WEST SUSSEX COUNTY COUNCIL CONSULTATION

TO:	Arun District Council FAO: Raymond Cole
FROM:	Stephen Gee WSCC - Highways Authority
DATE:	21 January 2021
LOCATION:	Land to the East of Fontwell Avenue Fontwell
SUBJECT:	WA/85/20/DOC Approval of details reserved by condition imposed under ref APP/C3810/V/163143095 (WA/22/15/OUT relating to Condition No 5 - scheme of phasing for construction.
DATE OF SITE VISIT:	n/a
RECOMMENDATION:	More Information
S106 CONTRIBUTION TOTAL:	n/a

Drawing Title
Phasing Plan

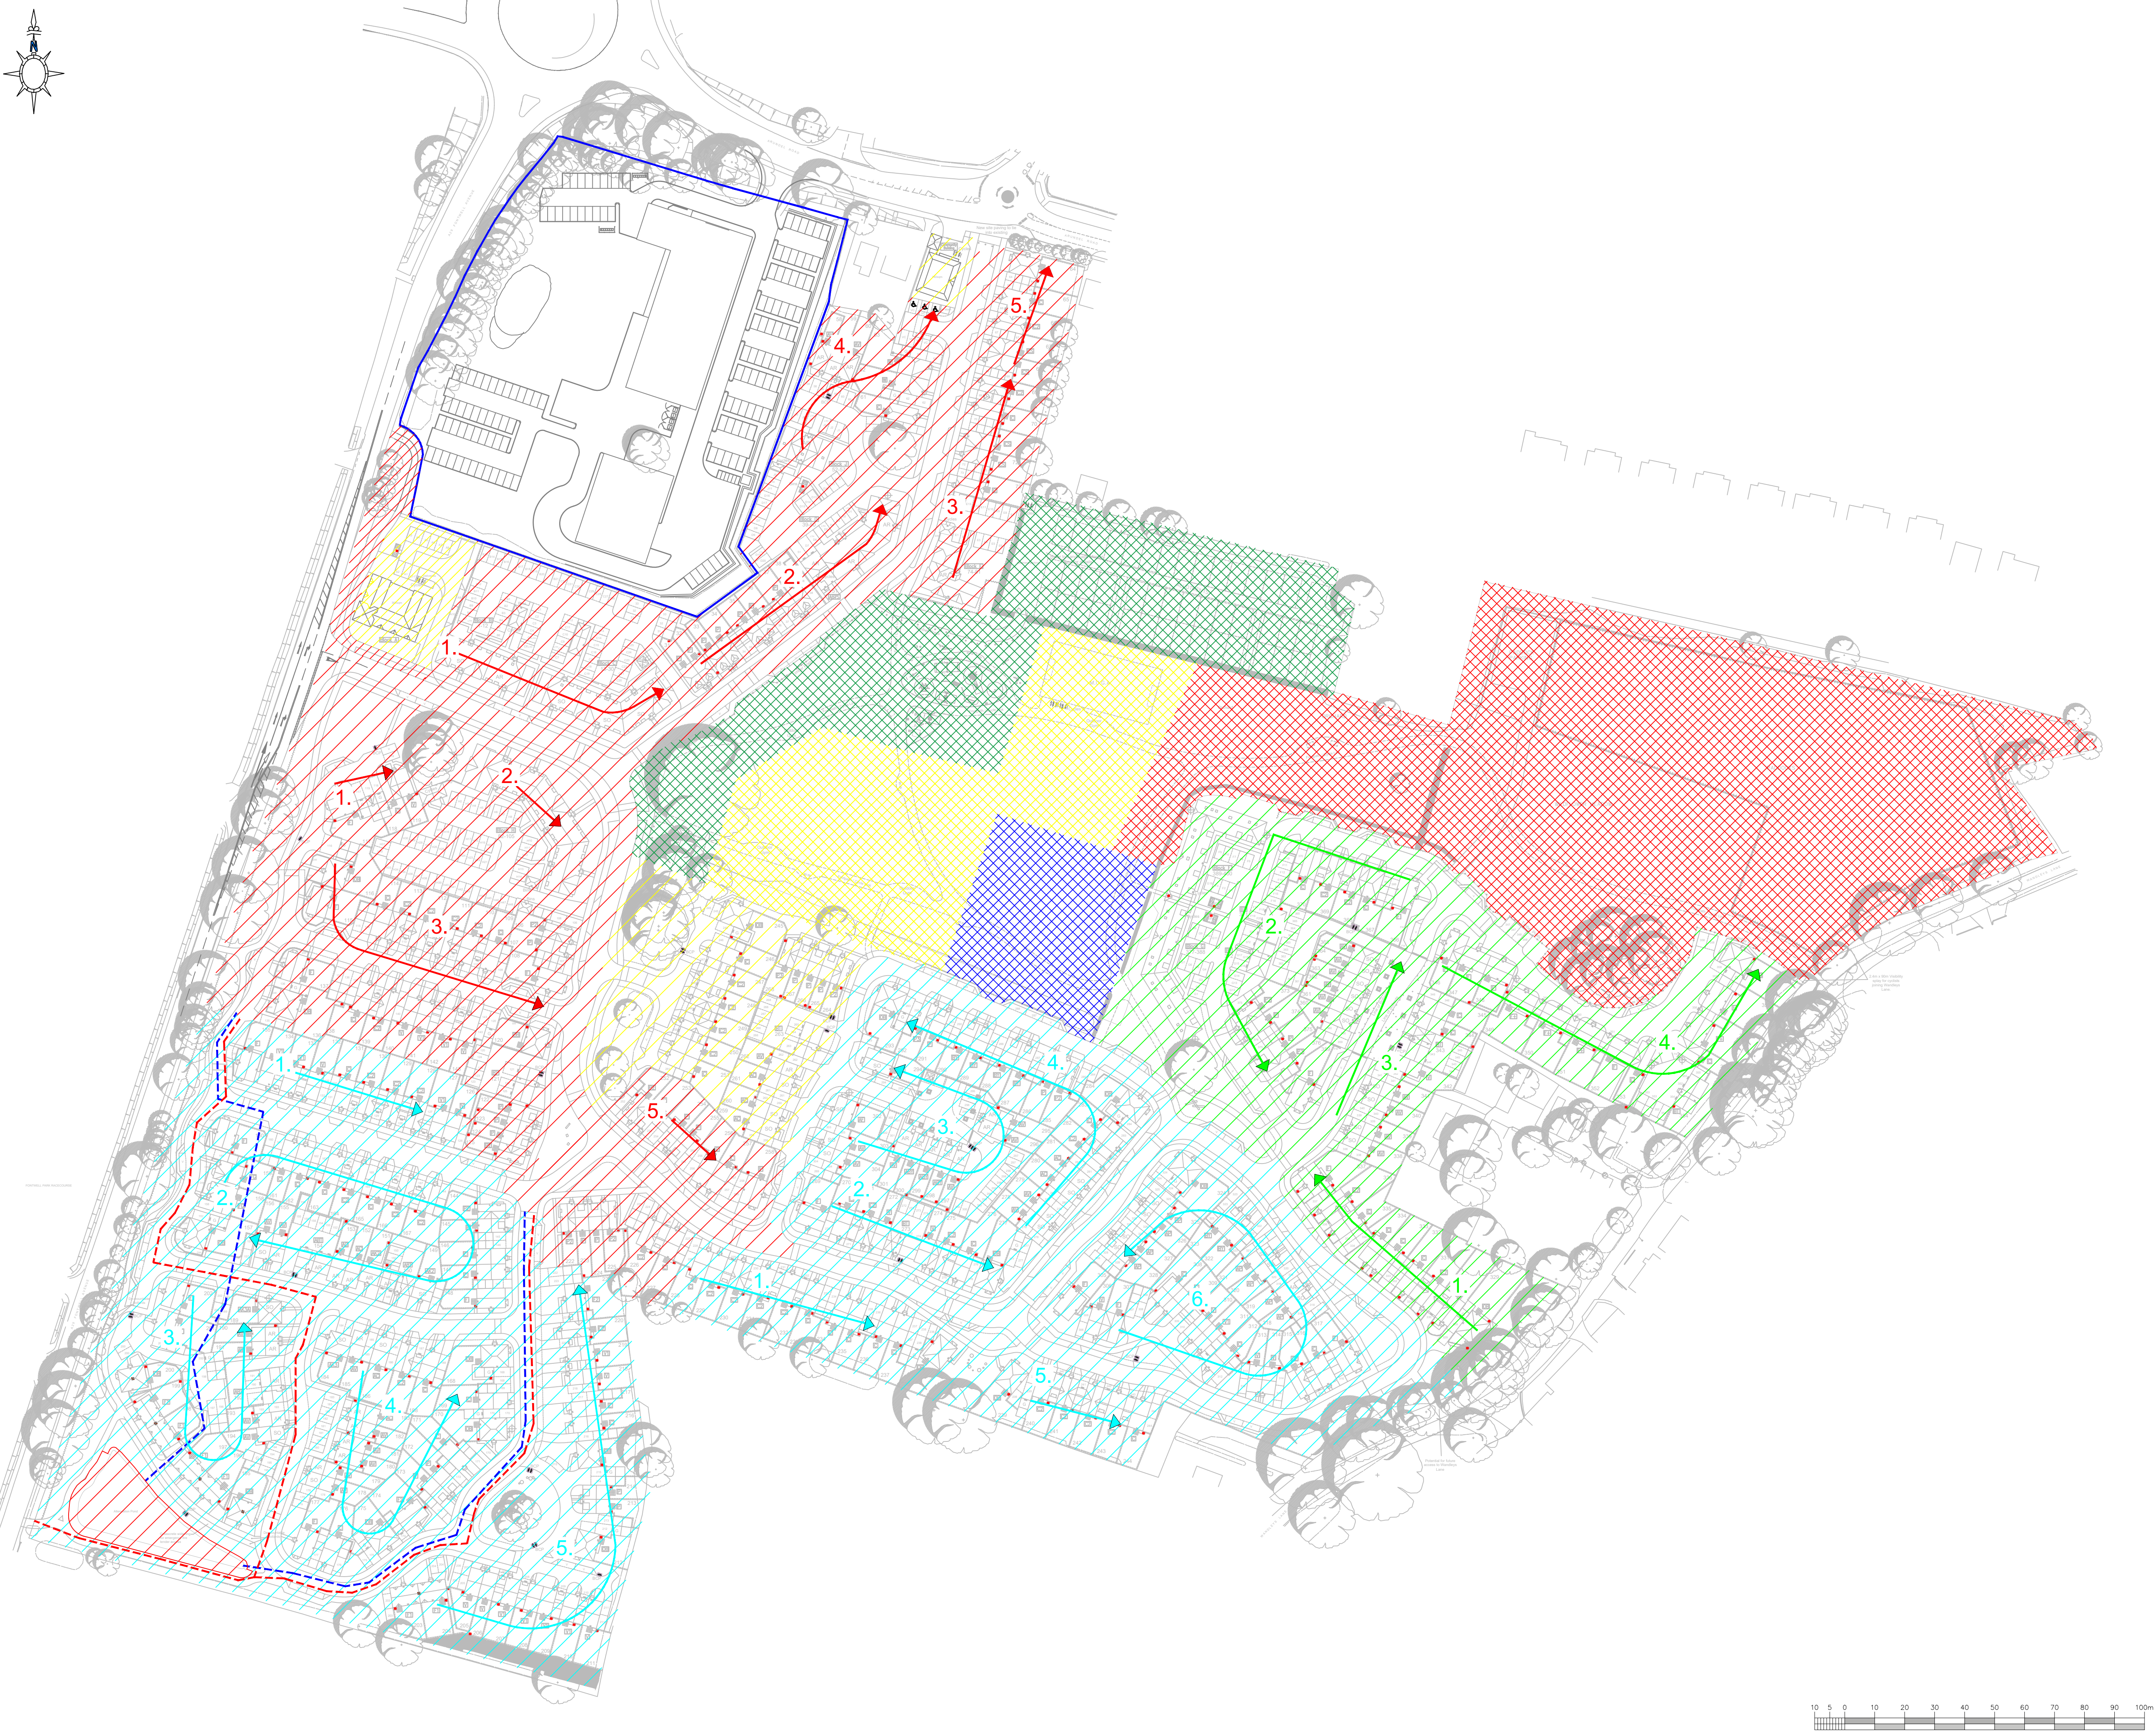
Details should be provided on the timing of access to be provided onto Fontwell Avenue within phase 1. It is not clear if the applicant intends on the occupation of any dwellings whilst only the access onto Arundel Road is available. Once the access onto Fontwell Avenue is being utilised details of how the access onto Arundel Road will be restricted and amended into the emergency access only as secured via condition 27 of the original application.

Additional details of how the internal footpath will be provide alongside Fontwell Avenue prior to the junction works commencing (as per section 4.13 of the NMU submitted under condition 26 discharge application ref WA/100/20/DOC)

Footway/Cycle way link onto Wandleys Lane,

The provision of the link appears to come late into the development, either this should be brought forward or an interim route across the site identified.
